From: Amanda Scholes on behalf of Planning.Responses
Sent: 18 November 2021 11:39
To: Hannah Riddle
Subject: FW: Water Lane, Angmering - Sales Cabin S73 - A/231/21/PL
Attachments: DAS - 17.11.21.pdf; P1320.SALES.01.D - Sales Area Layout.pdf; A.231.21.PL - Action Sheet.docx

Please upload onto Ocella the **SUBSTITUTE Design and Access Statement (attached)** and the **Layout Plan (attached)** for **A/231/21/PL**.

- Drawing No. P1320 SALES.01 **Rev. D** - Sales Area Layout.
- Revised Design and Access Statement: Land South of Water Lane, Angmering - Temporary Sales Cabin, **dated 17th November 2021**.

Subject: Water Lane, Angmering - Sales Cabin S73

Scale	1:200 @ A2	Drawn	DGP	Checked	DGP
Date	November 2020	File	P1320 Sales Layout	Drawing Status	
Drg.No.	P1320.SALES.01	Rev.	D	PLANNING

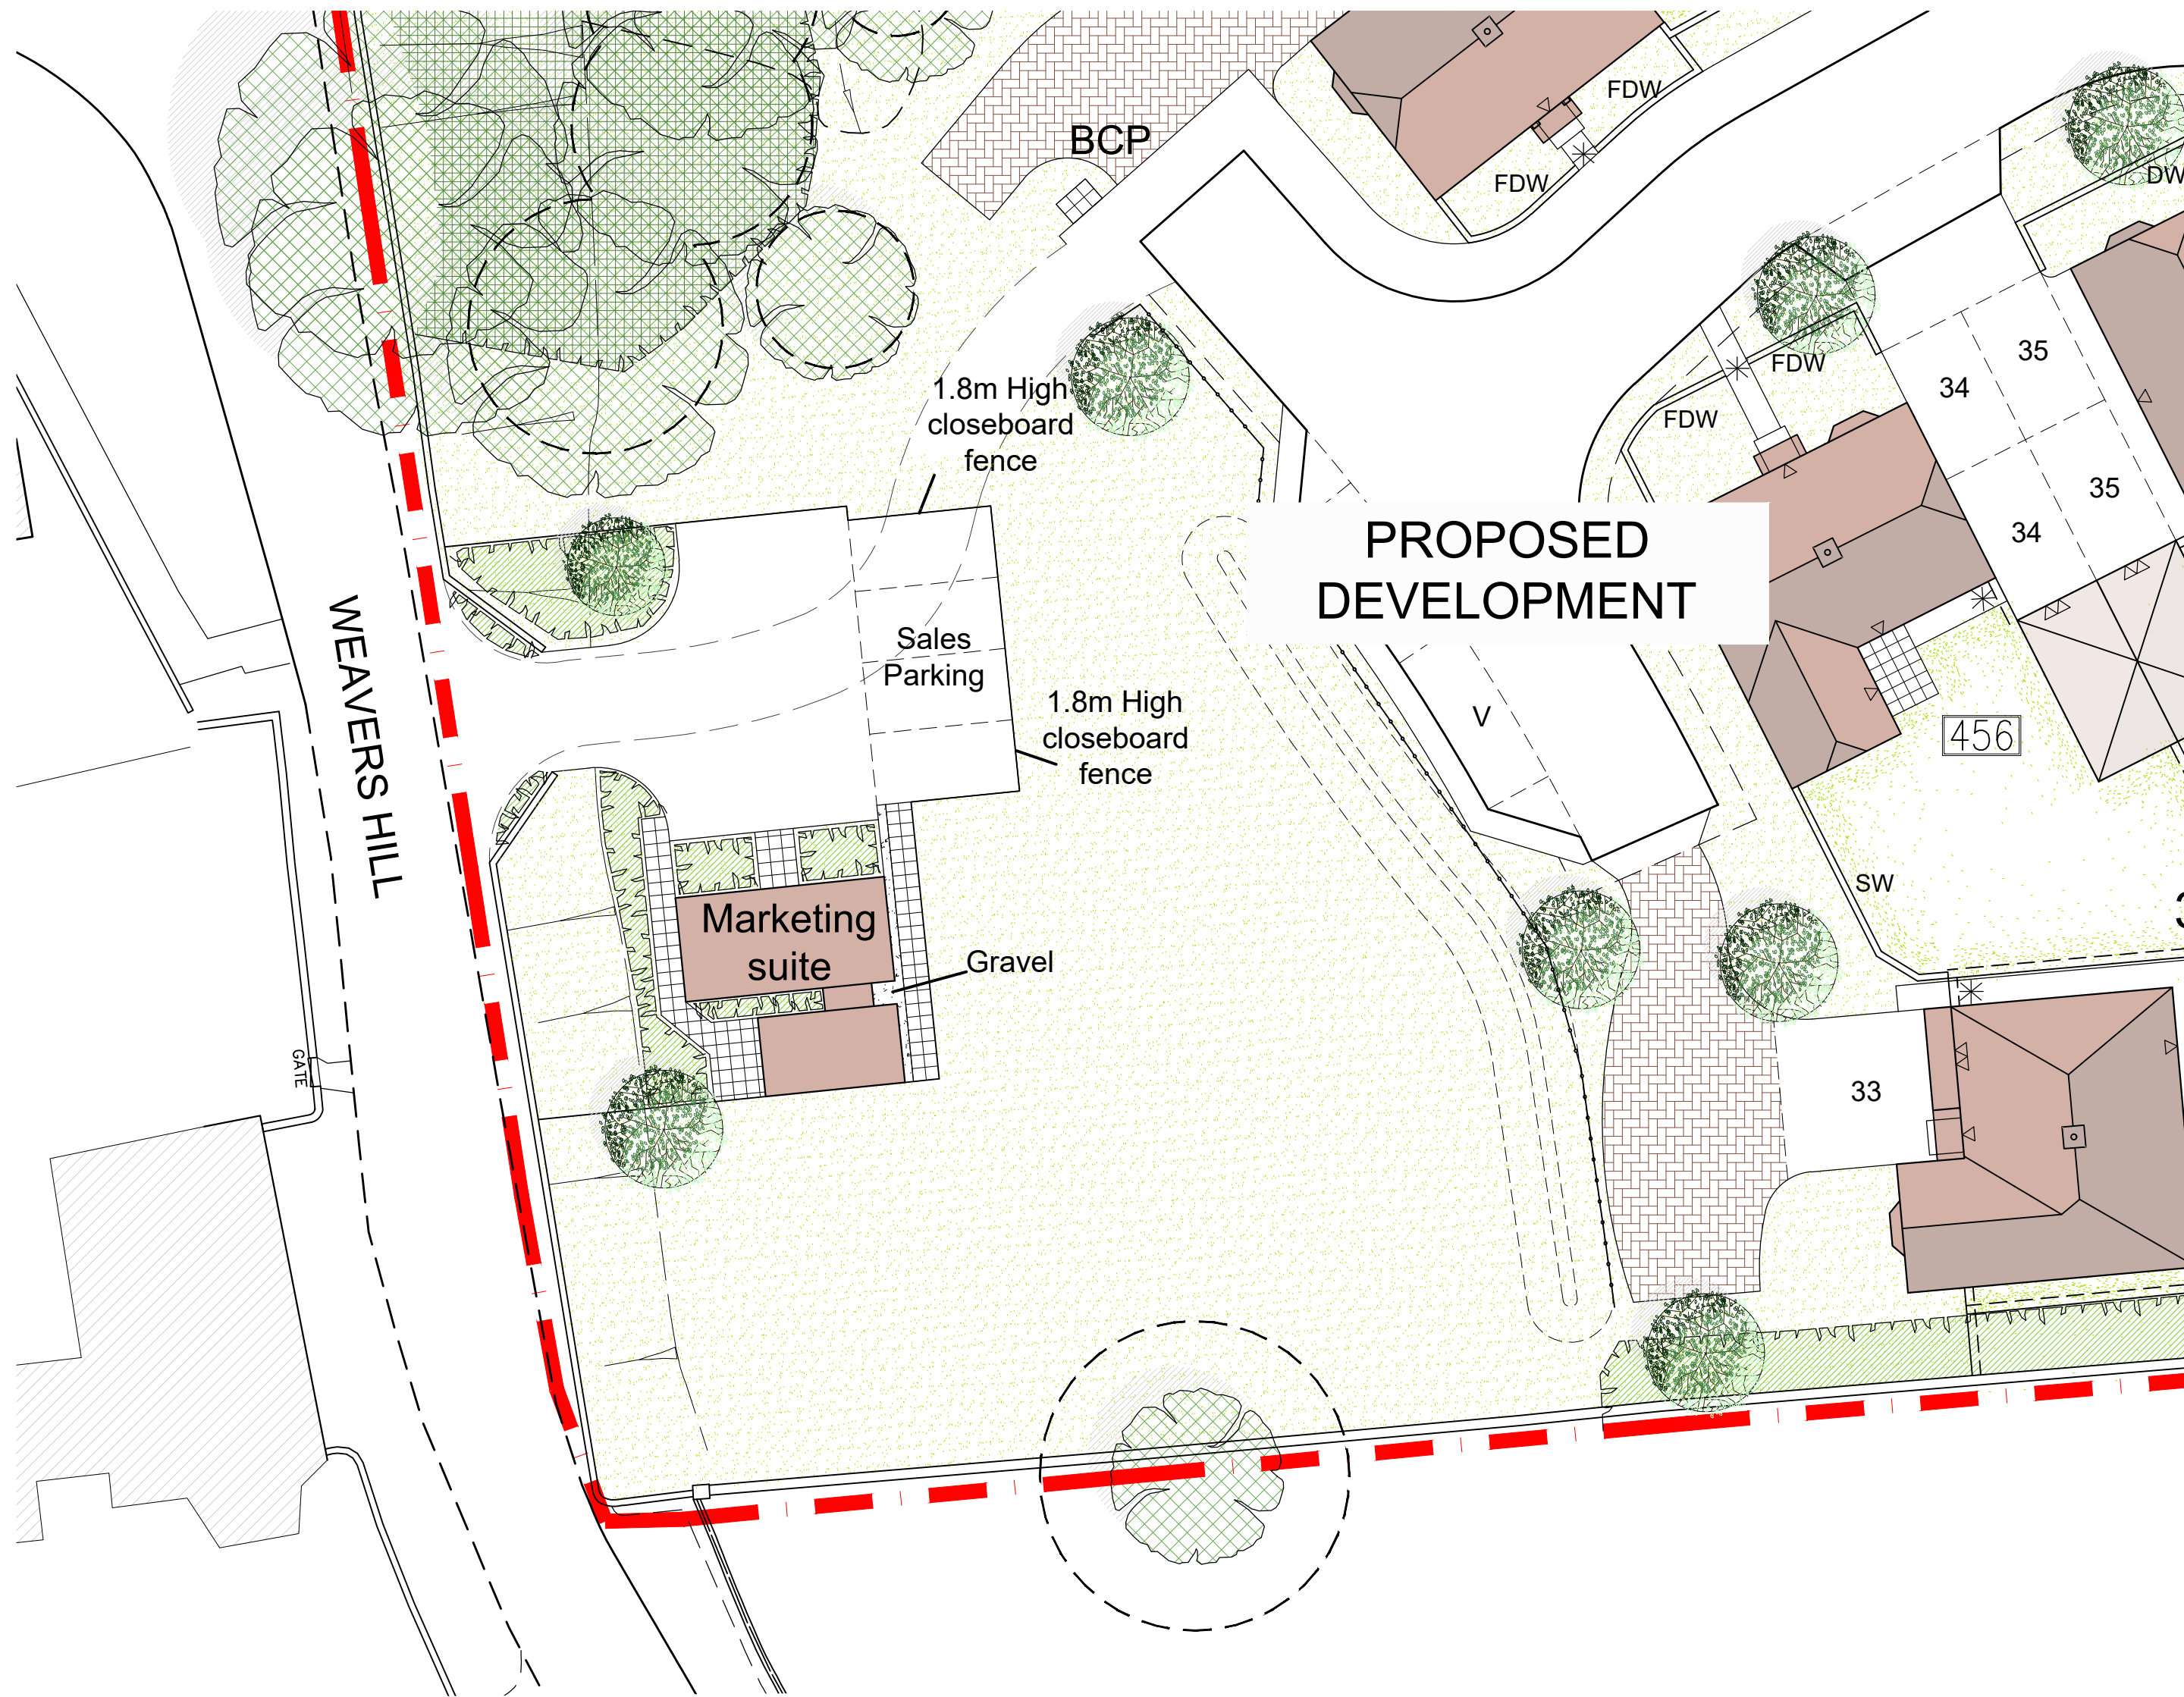
As discussed, please find attached an updated Block Plan and DAS reflecting a 1.8m closeboard fence instead of 2m hoarding.
